Your Ref: 2024/92806
Our Ref: A004916

13th November 2024

Land at Penistone Road, Fenay Bridge, Huddersfield – Discharge of details reserved by conditions 20 (surface water discharge), 21 (flood routeing) of previous permission 2022/93154 for erection of 68 dwellings with associated access, parking, open space, landscaping and infrastructure works (including installation of surface water attenuation tank)

Title: Exceedance Flow Routes

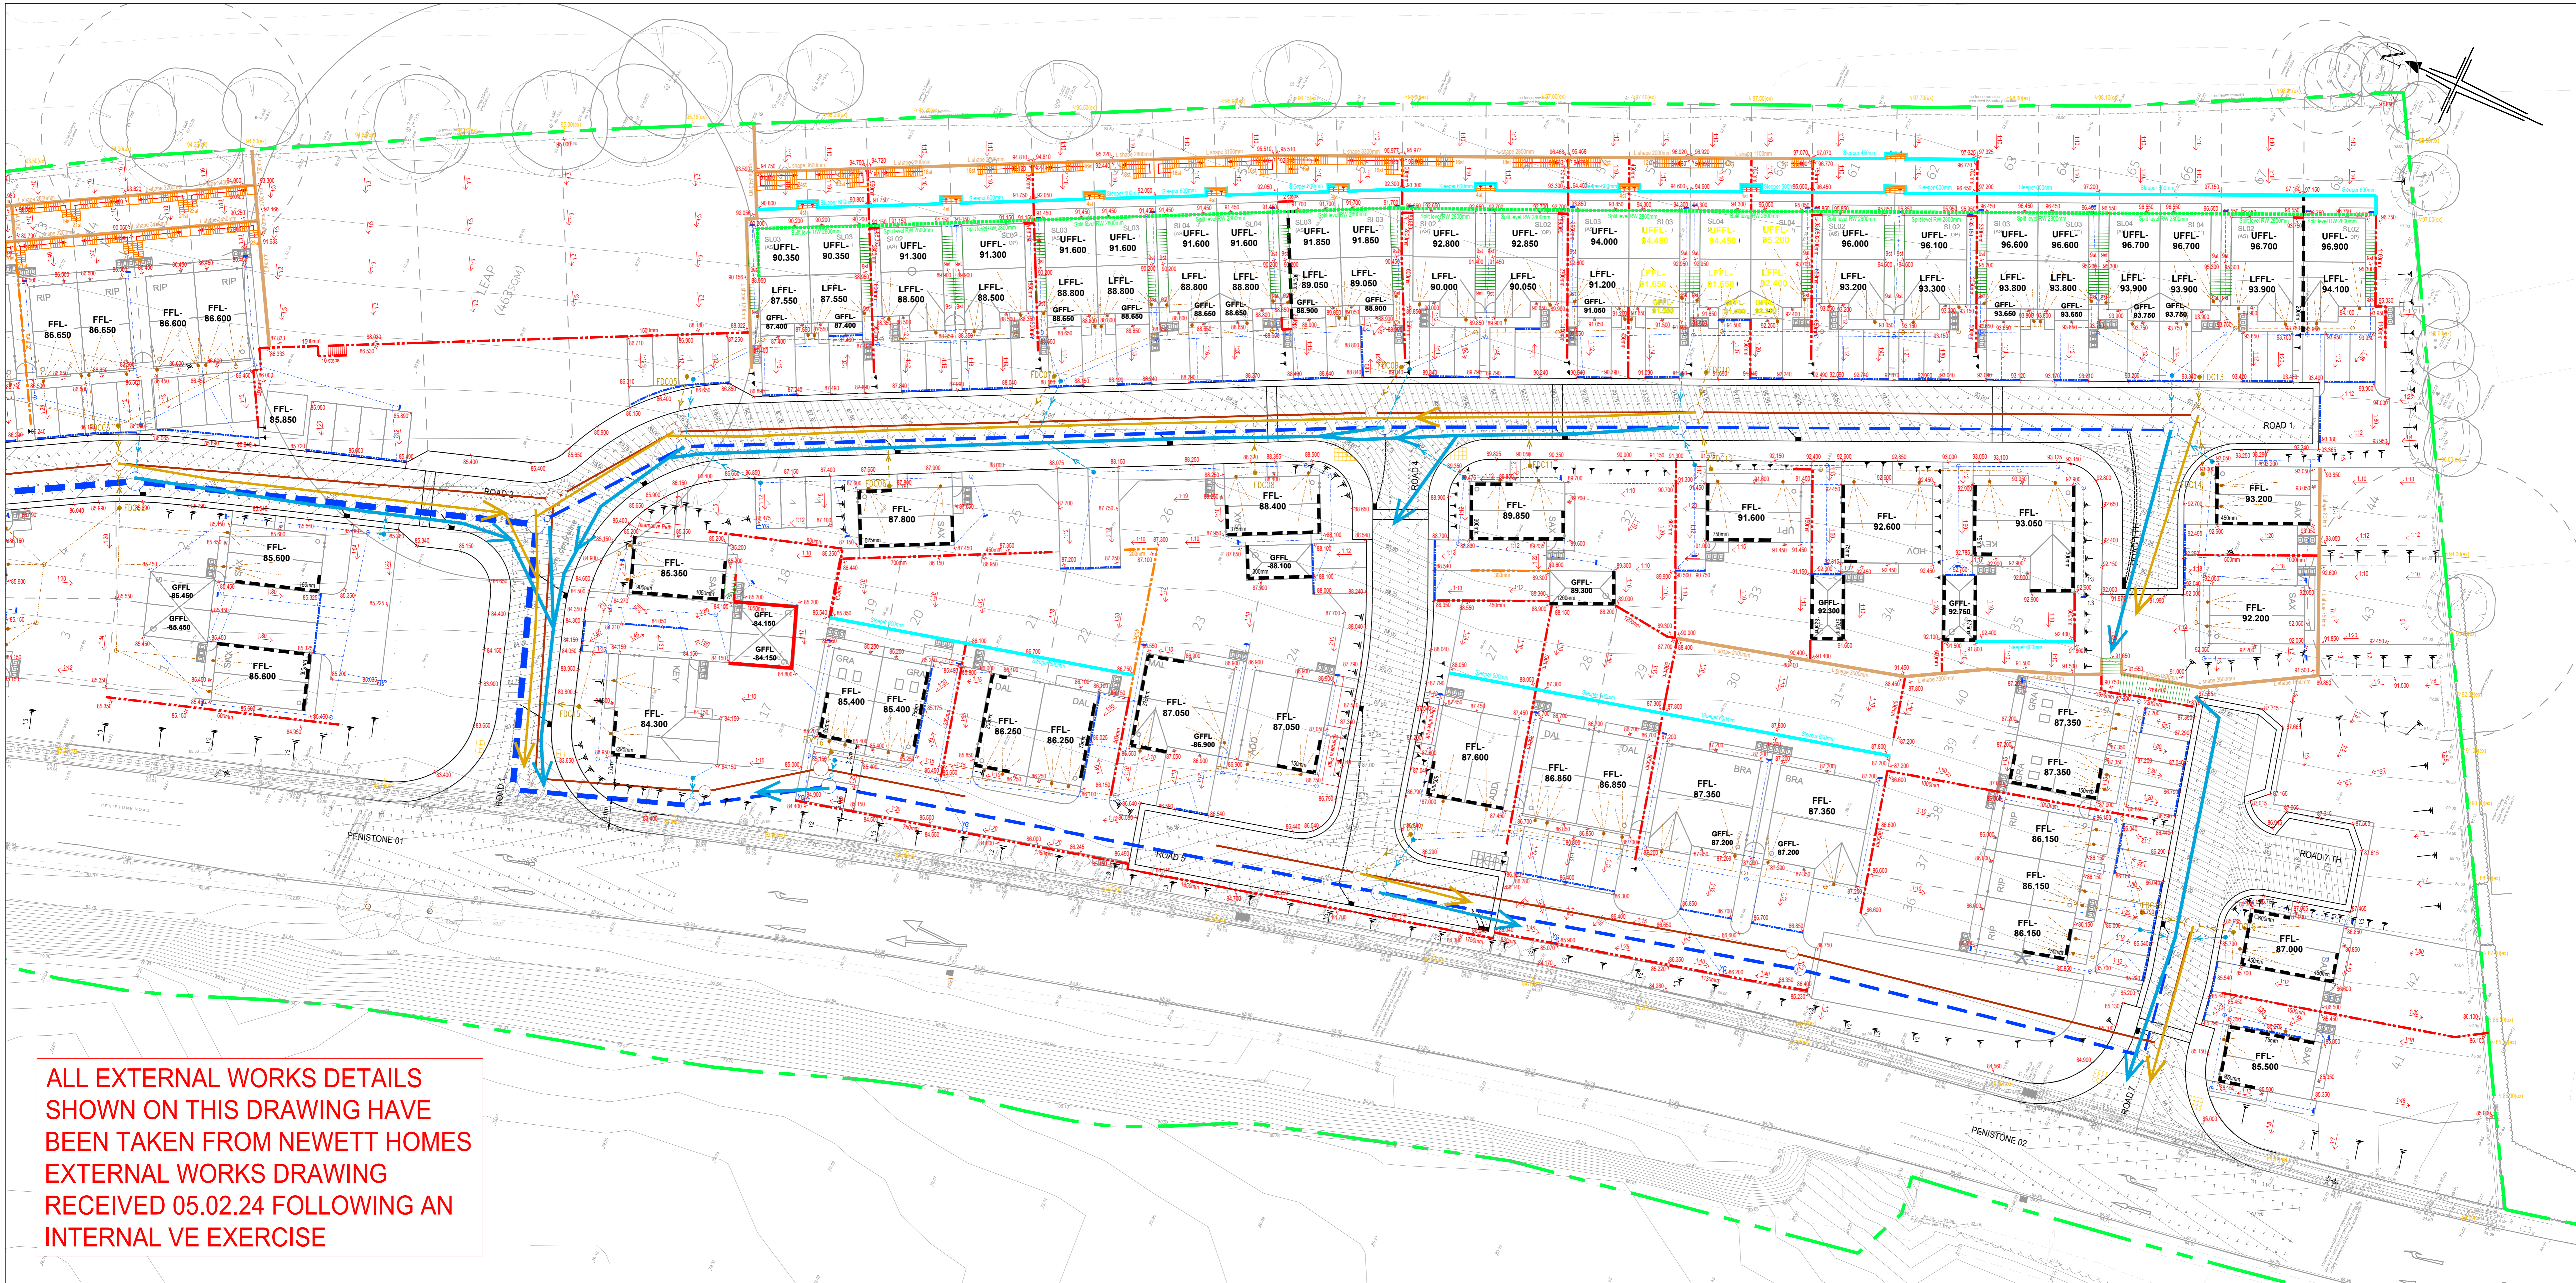
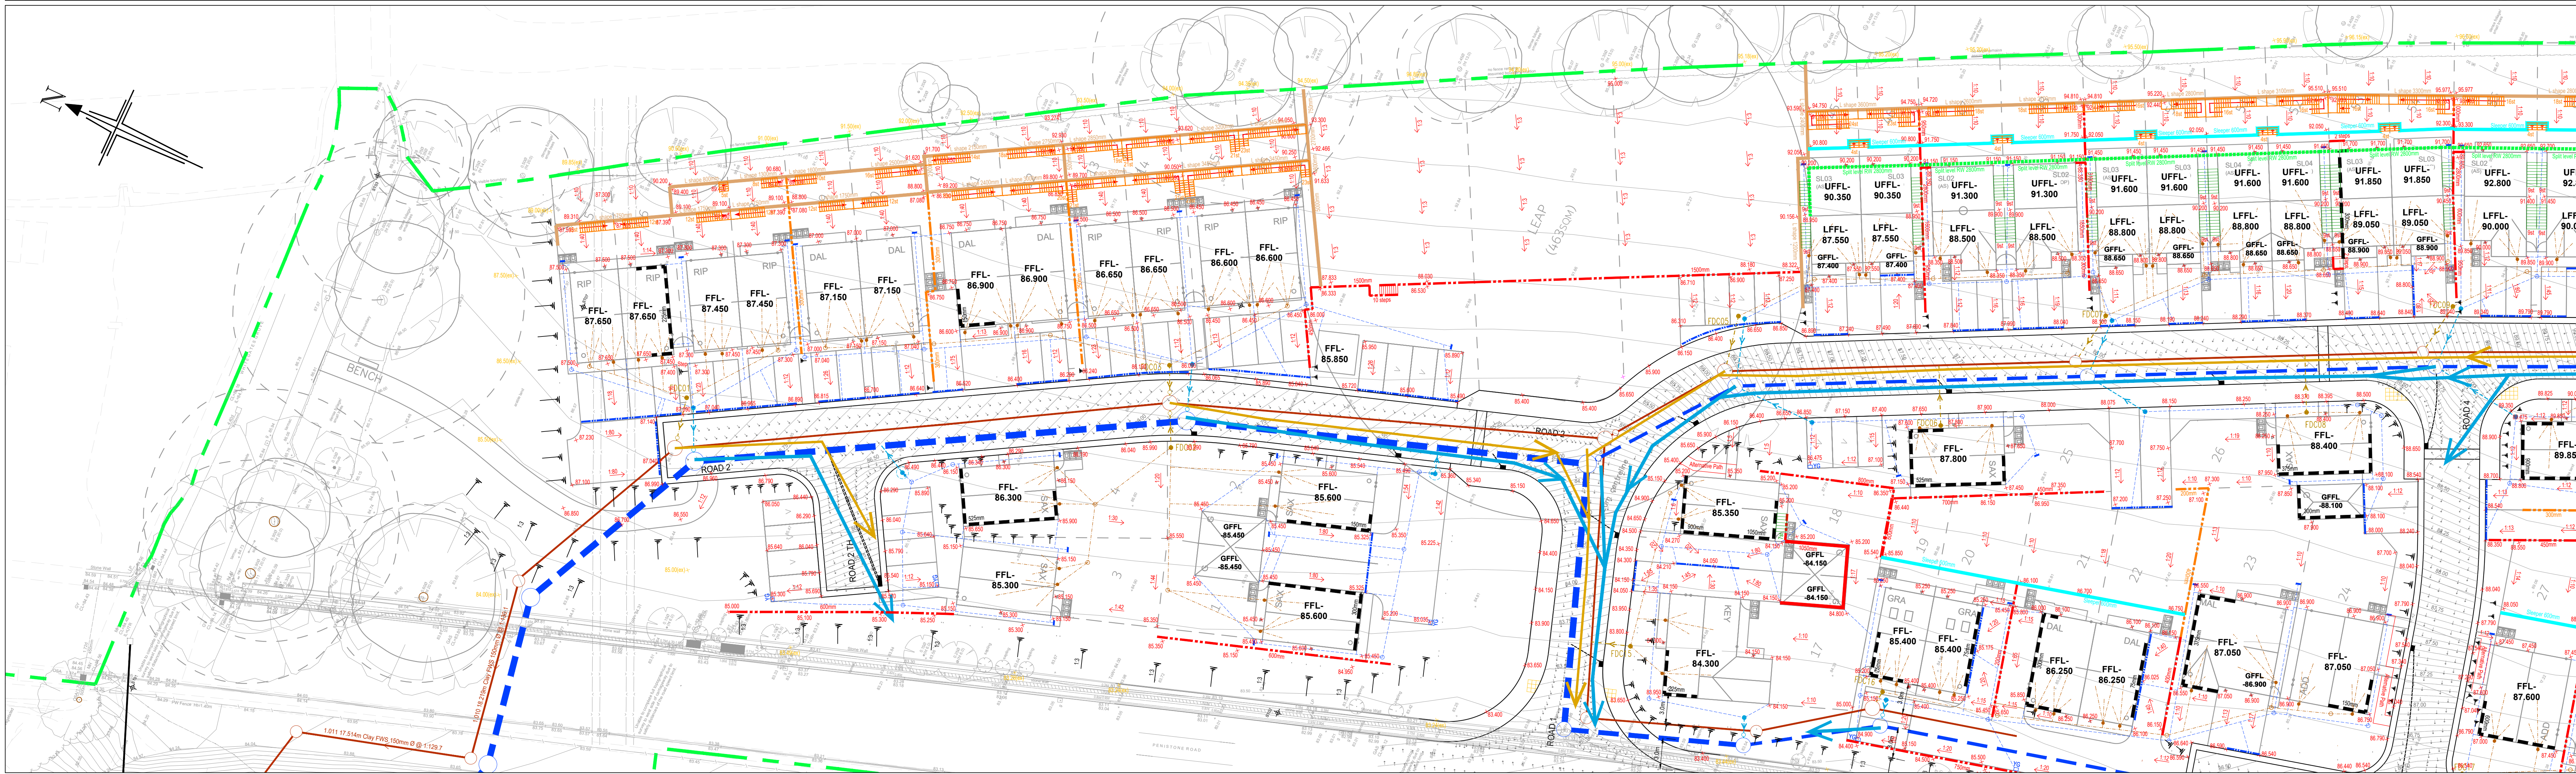
Yorkshire Water objects to the discharge of condition 20.

The submitted drawing, Exceedance Flow Routes 22/491/500/007 (revision C) dated 22/02/2024 prepared by Bryan G Hall is unacceptable. Clear plans are required which should show the off-site connections for both foul and surface water drainage and should be clearly labelled accordingly.
